Re: 250/274 Parkdale Avenue Mixed-Use Development CTS/TIS Addendum #1

This Addendum has been prepared to respond to the comments received from the City of Ottawa, dated November 22, 2013, with regard to the above-noted CTS/TIS.

ZONING BY-LAW REVISED CONCEPT PLAN

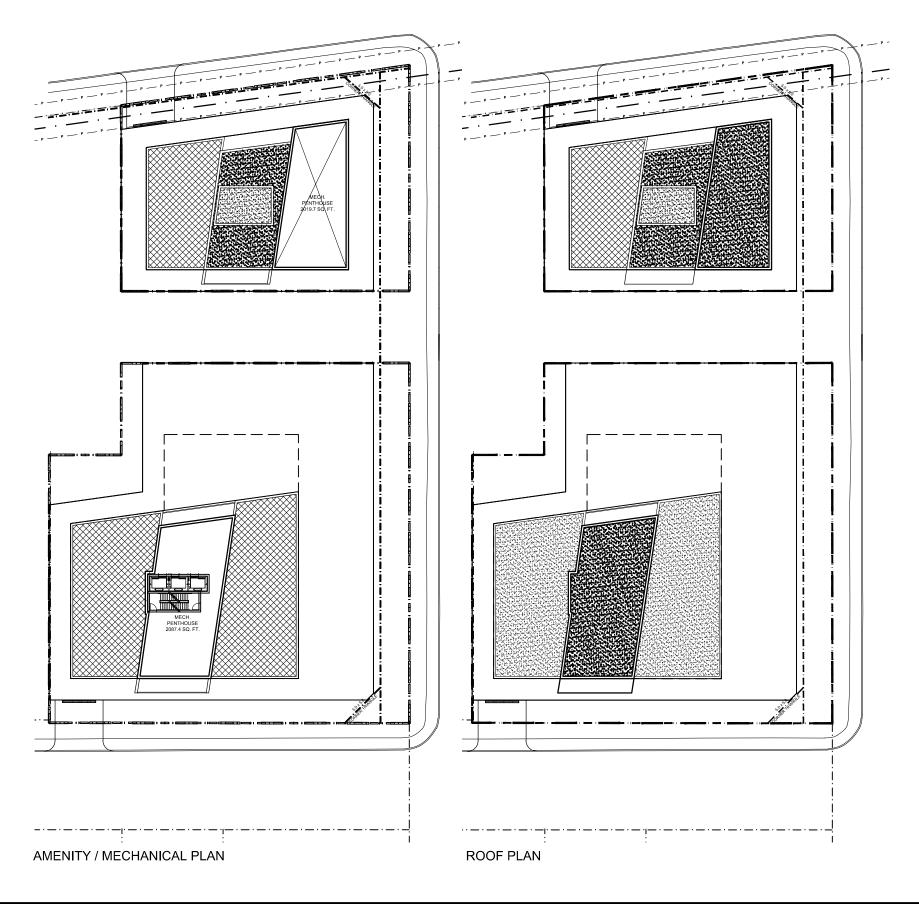
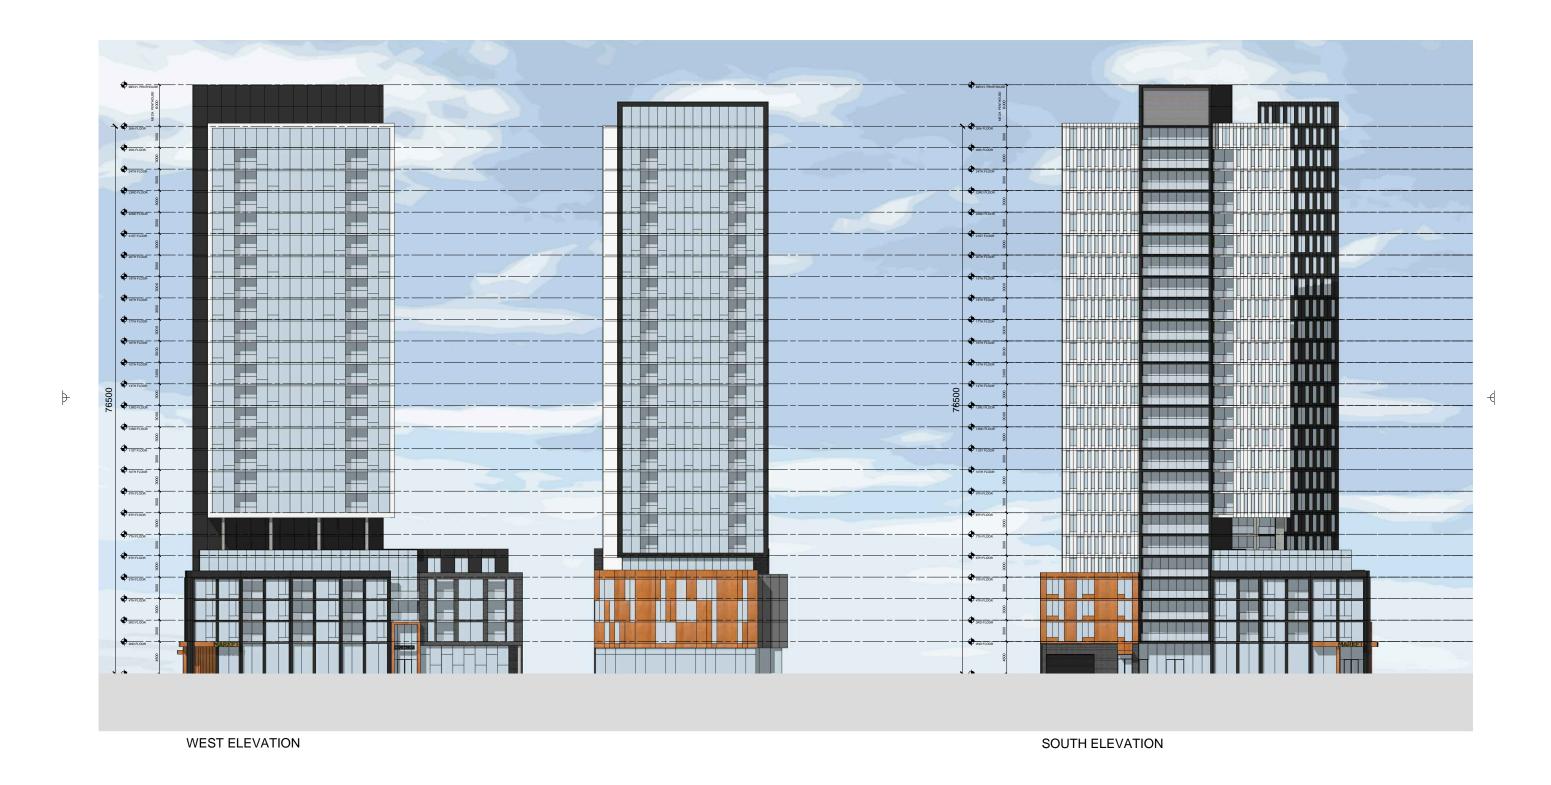
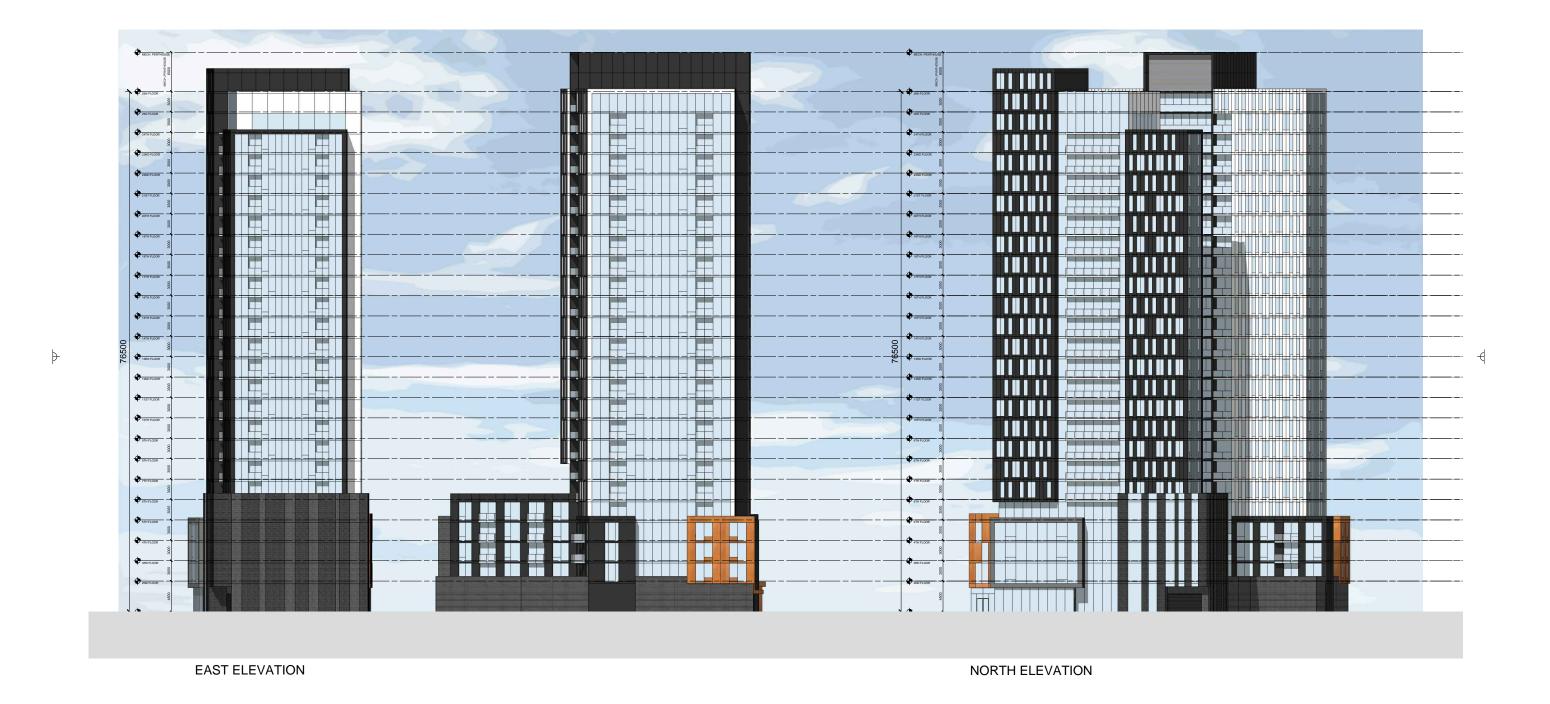
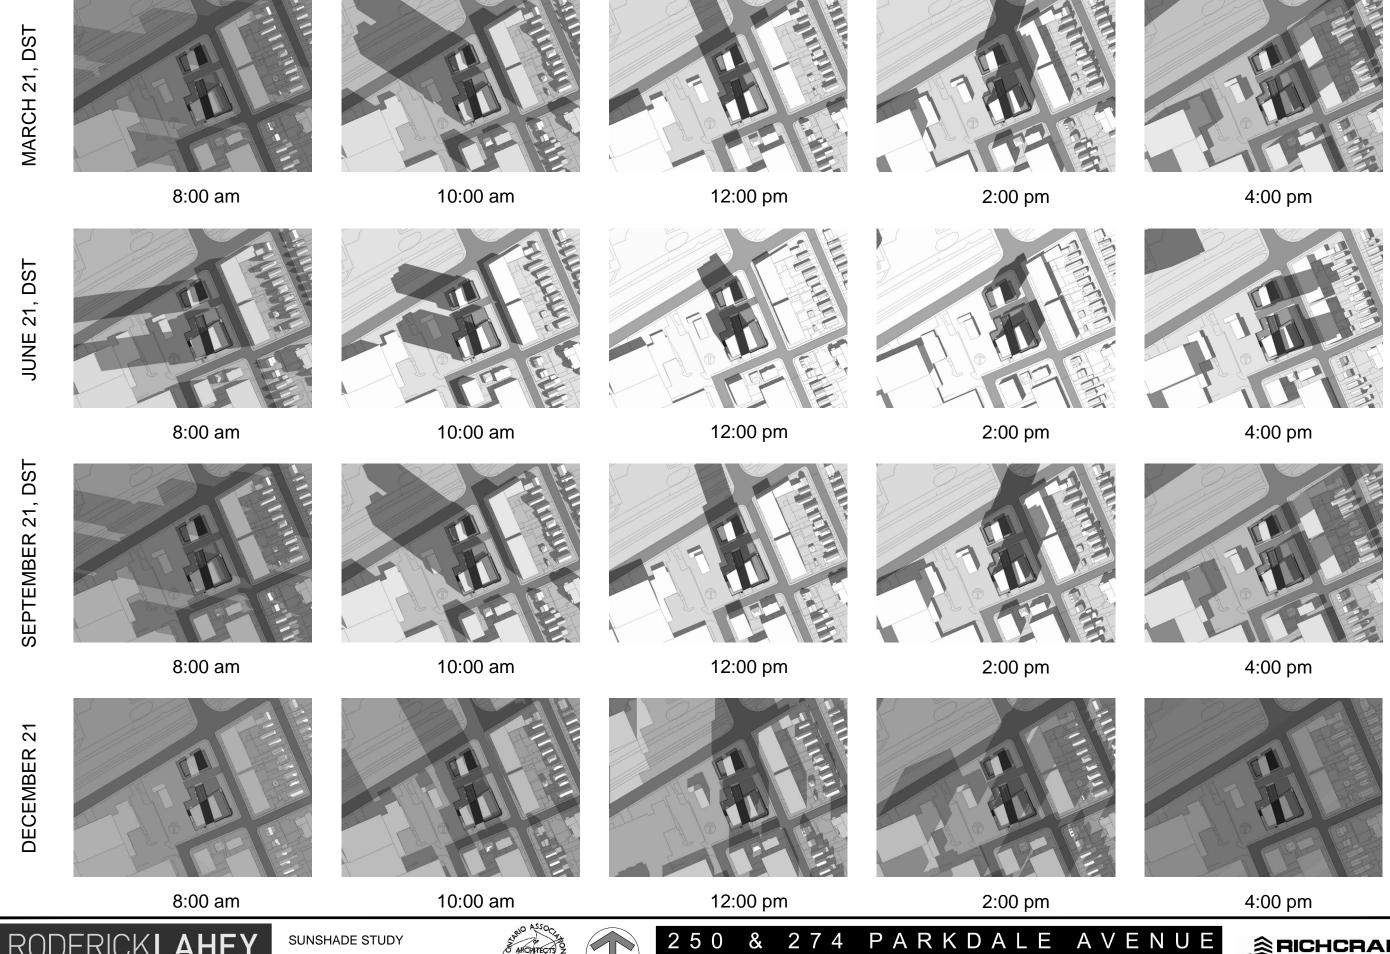
Comment 5: Demonstrate how a turning lane could be provided and that there is sufficient space for pedestrians and boulevard for trees illustrated on the site plan that accompanies the Zoning Amendment.

Comment 7: Ensure that the building does not extend into the right-of-way protection area.

Response 5: As mentioned previously, the OP identifies a 26 m ROW protection for Parkdale Avenue, from the Ottawa River Parkway to Wellington Street West. With a 26 m ROW, a 3 m setback, a 2.5 m boulevard, a 2 m sidewalk and a 3.5 m travel lane can be accommodated on either side of centerline, with a 3.5 m center turn lane.
